Our ref: SSD-45024776 | Narwee Parklands Seniors Housing

24 March 2023

Subject: Request for Additional Information

**Figure 2** 9.5 Housing SEPP height compliance diagram as viewed towards the northwest (grey illustrates the servicing equipment – compliant with the 11.5m Housing SEPP height plane)

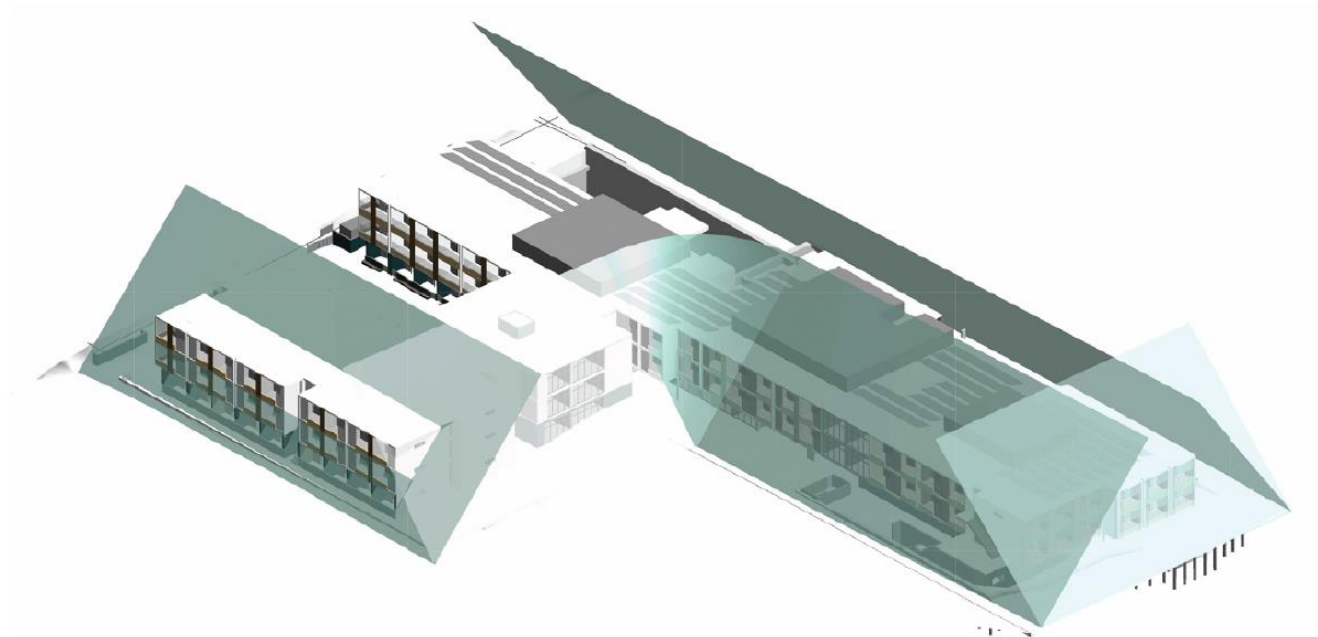
- (a) The proposal seeks a variation of 11.6% to the maximum building height development standard and makes no attempt to comply with the 45 degree plane development standard at the southern end of the development as prescribed by the *State Environmental Planning Policy (Housing) 2021* (Housing SEPP). The breach of these development standards results in unacceptable outcomes as discussed further below.

**Figure 7** Overshadowing analysis at the winter solstice (9am to 3pm)

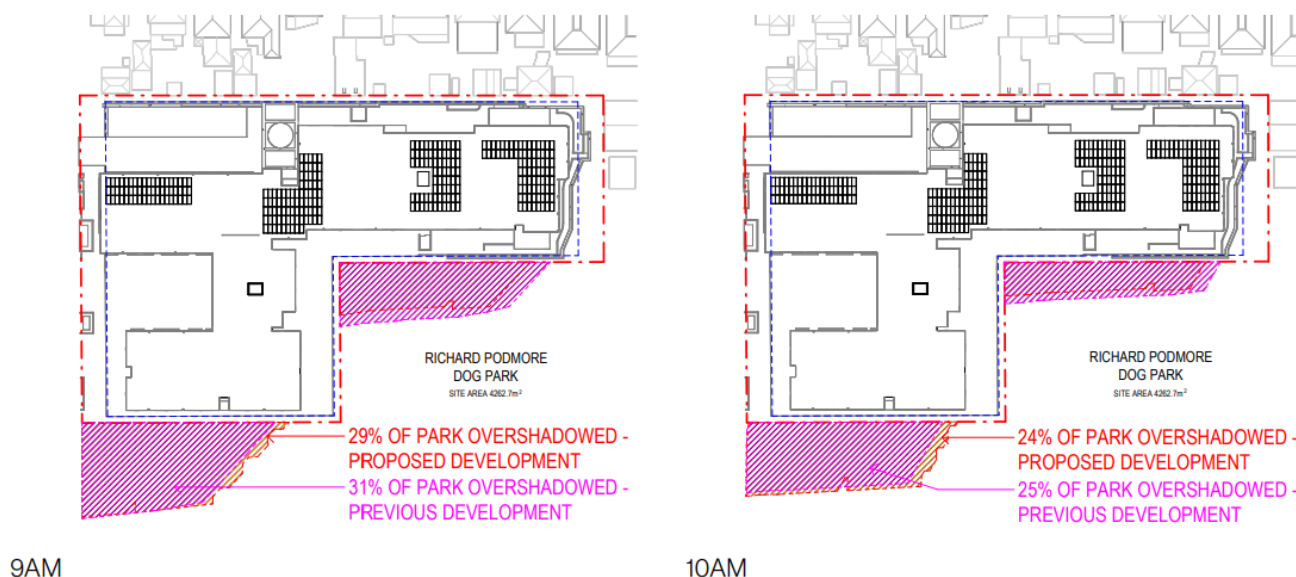
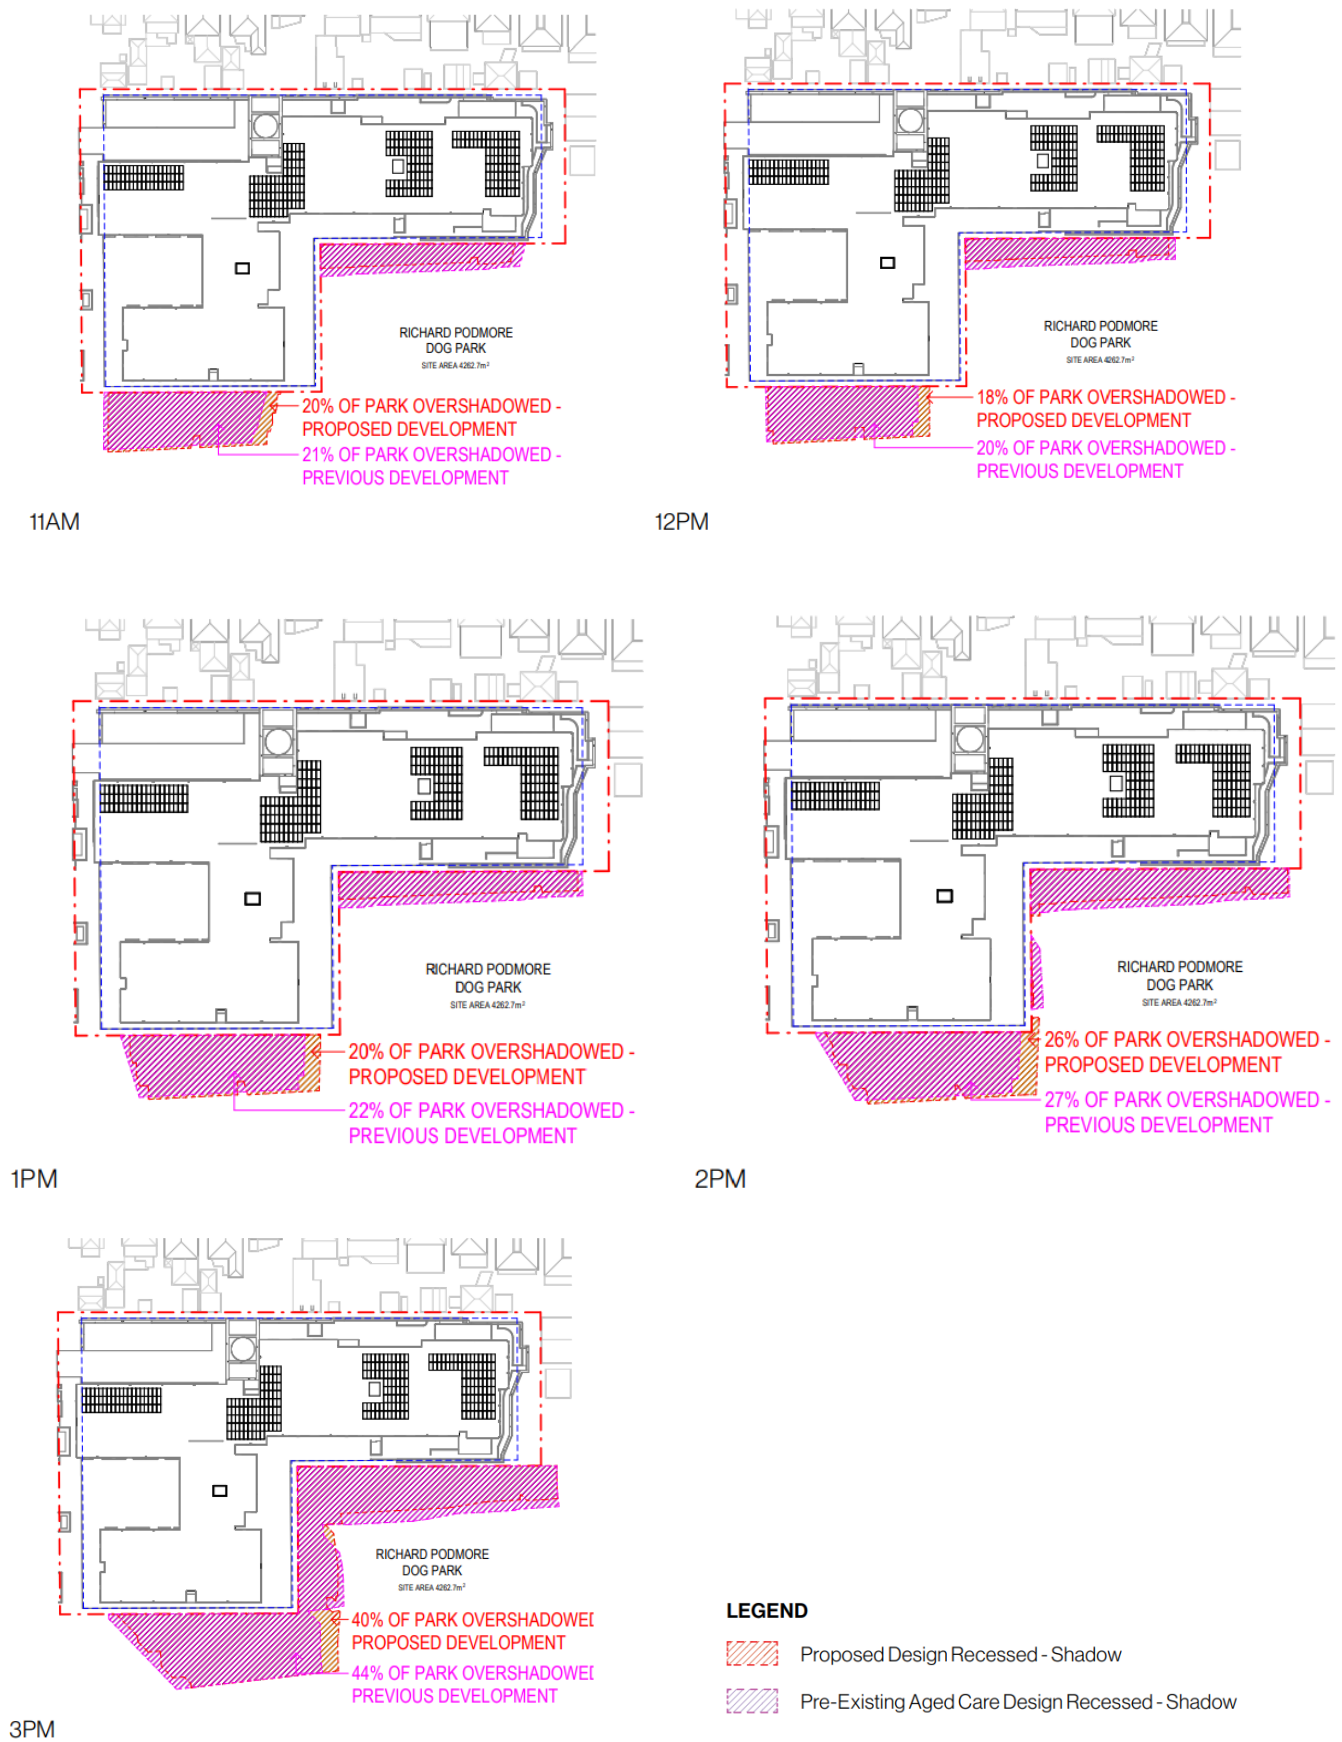
- (iii) The solar access analysis demonstrates that the proposed development results in greater overshadowing impacts to Richard Podmore Reserve than a complying built form during the winter solstice. This has not been addressed in the Clause 4.6 submitted.

- (d) Amended shadow diagrams are to be submitted that remove reference to the previous development on the site. The shadow diagrams must compare the impacts of the proposal against a complying built form.

7.3m AMBULANCE VEHICLE
SWEPT PATHS

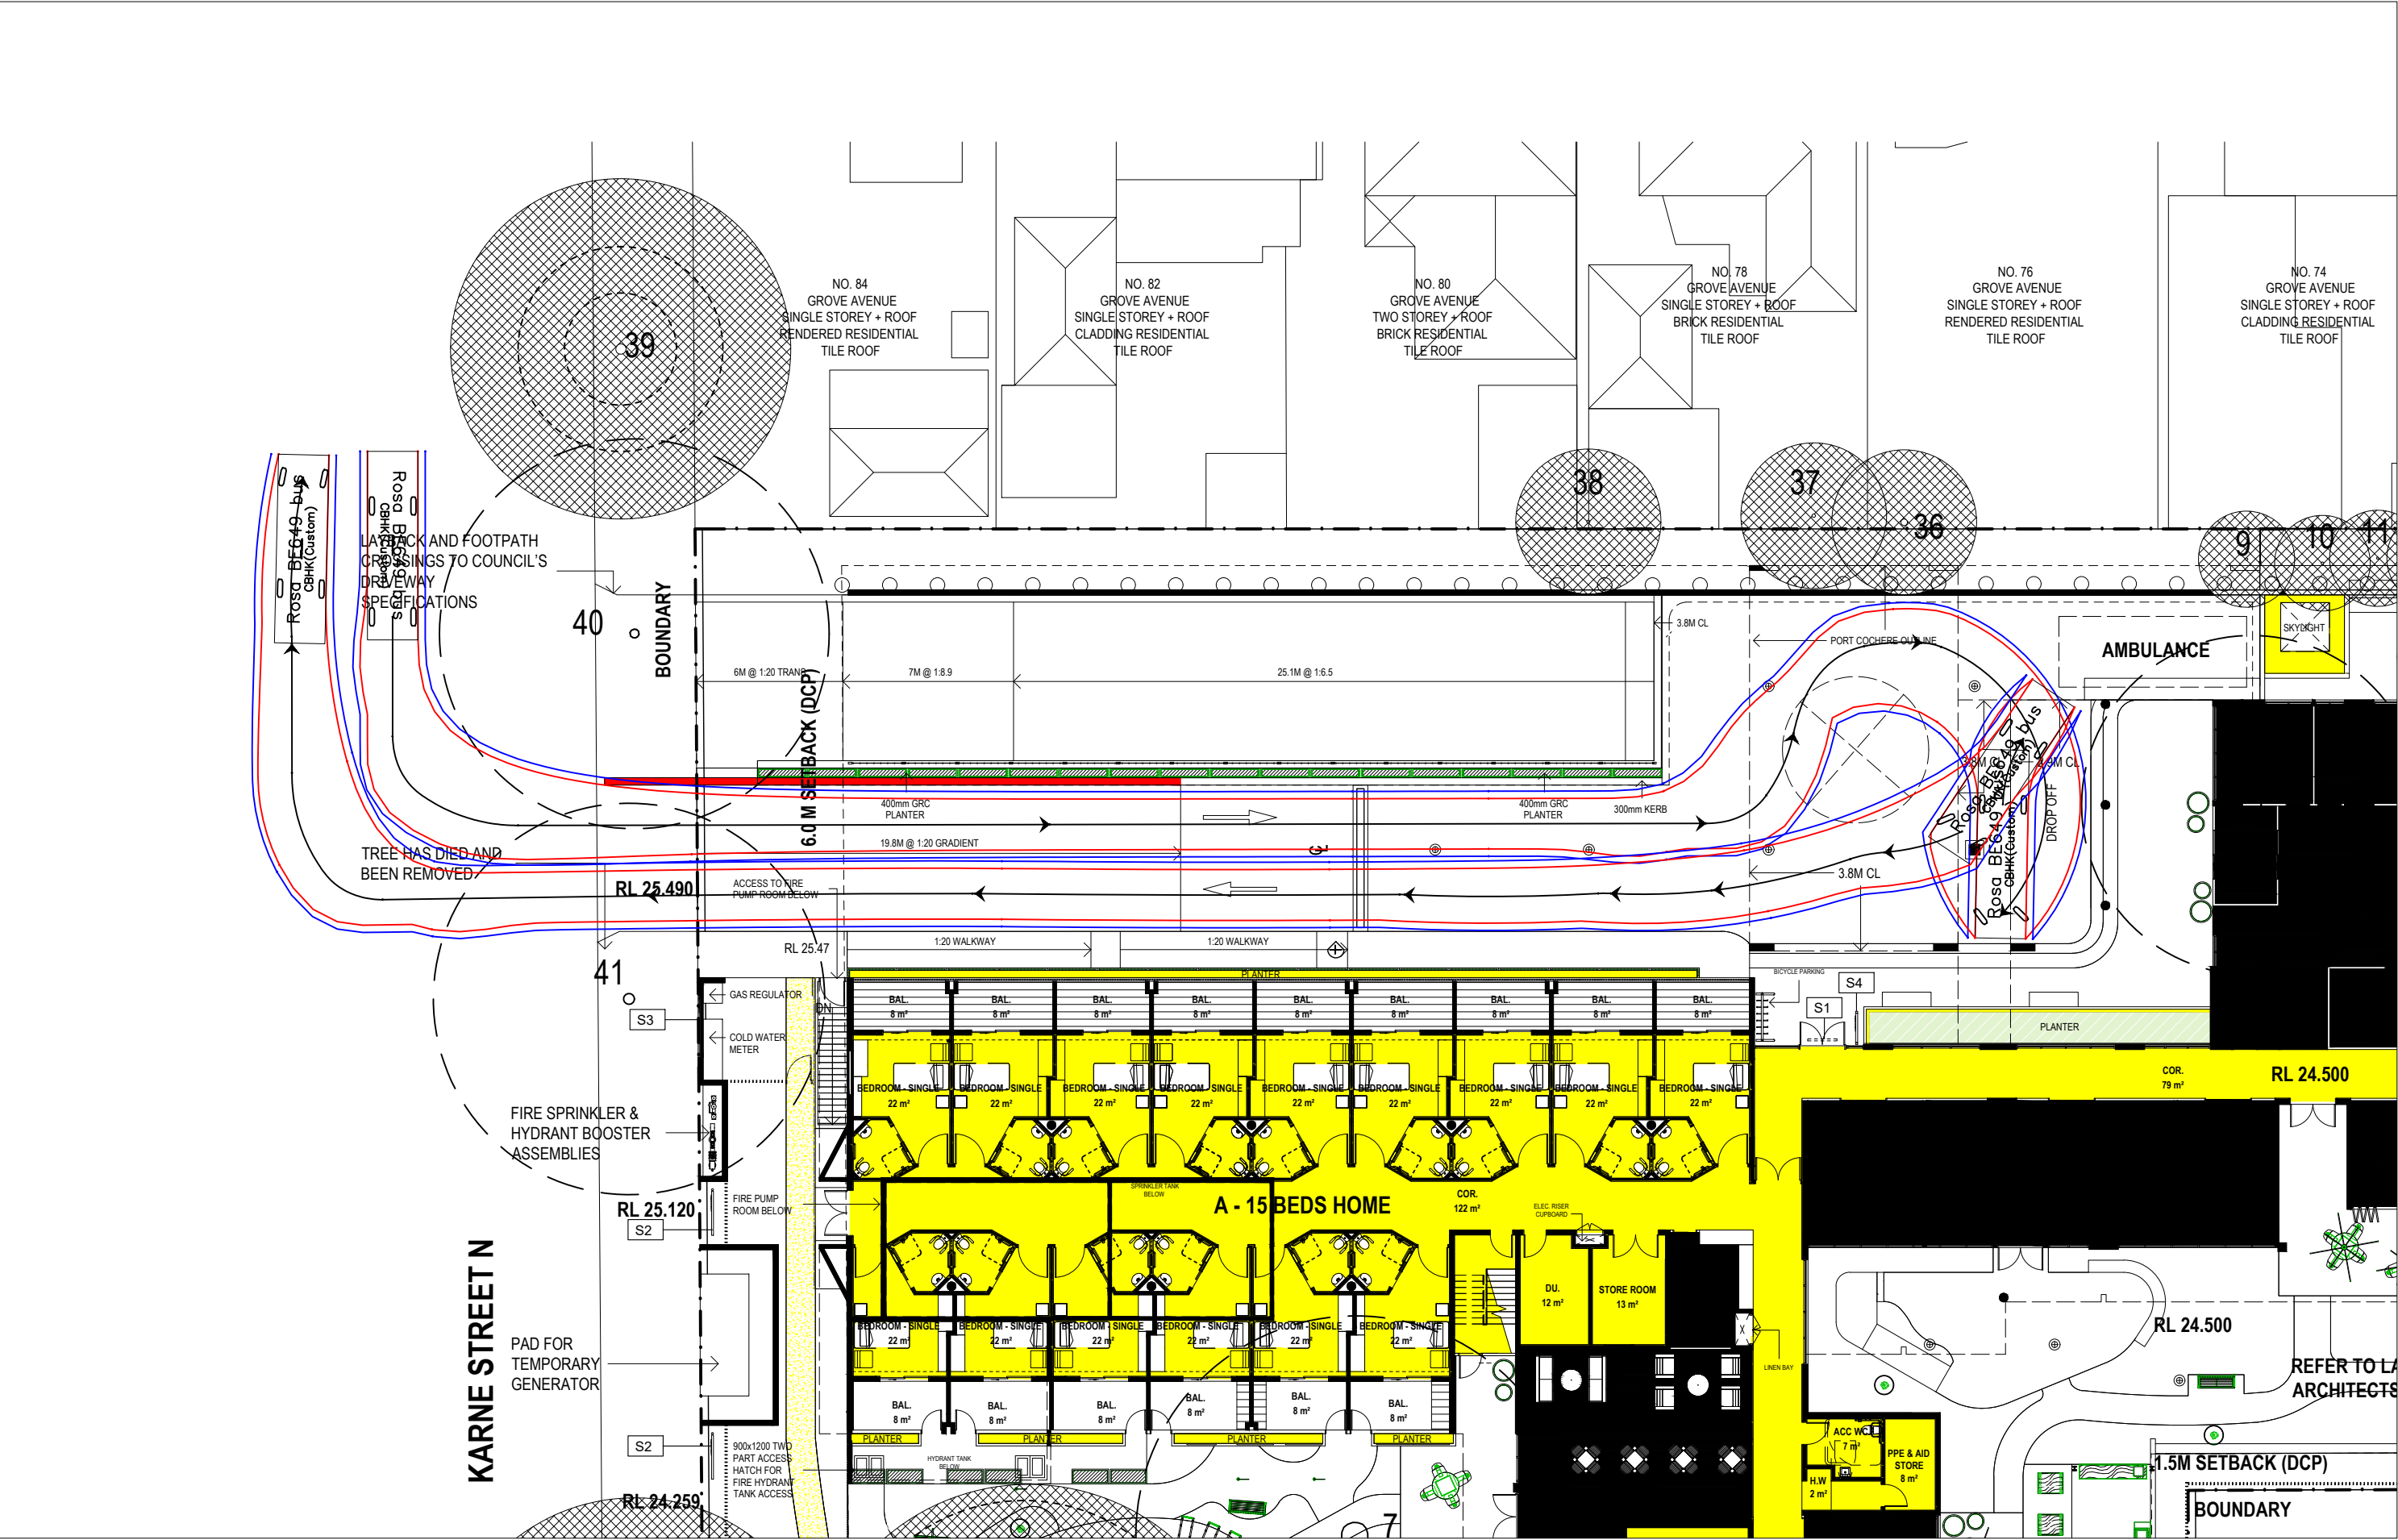
- (c) As raised by the SDRP, further detailed design work is to be implemented on the driveway/entry.
- (d) Further consideration is to be given towards the ambulance turning circle in accordance with the relevant standards in *Vehicle Access Specifications – NSW Ambulance*, noting the sensitive use and increased potential for ambulance attendance to the site.
- (e) The architectural plans must be amended to accurately identify the parking spaces breakdown including allocating for visitors and staff.
